Our ref: Valley of the Winds Wind Farm (SSD-10461)

14/10/2022

Subject: Valley of the Winds Wind Farm - Request for Additional Information

B1. Dwelling Assessment Dwelling 284

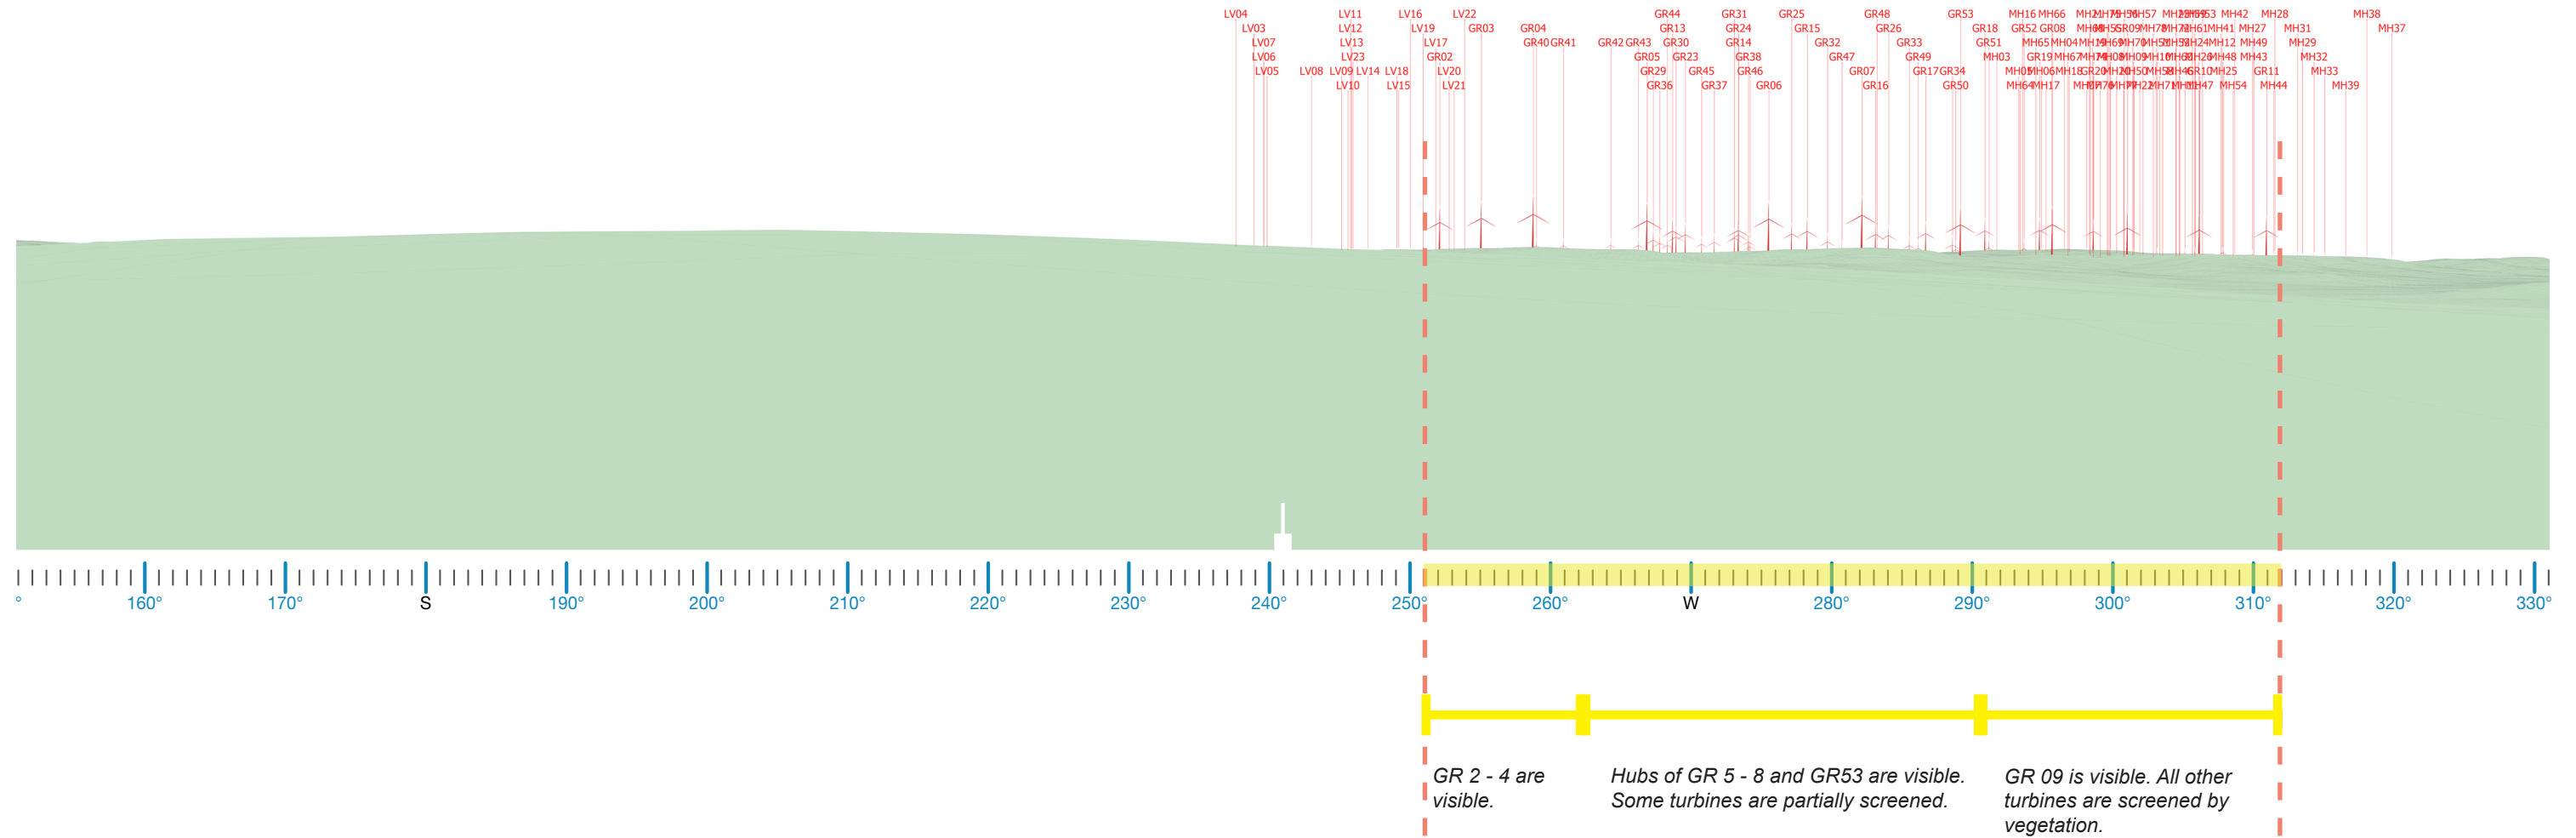
- full impact assessment, including photomontages and/or wireframe, from residence 284, and any other residences not assessed due to error or incorrectly labelled as 'associated' with the development, ensuring to capture all potential views of turbines; and
- update all photomontages to include turbine numbers and blue sky background.
- **Biodiversity:** Demonstrate avoidance and minimisation of impacts to the Box Gum Woodland Critically Endangered Ecological Community, and other biodiversity values in project design.
- **Traffic:**
 - review the adequacy of proposed intersection upgrades;
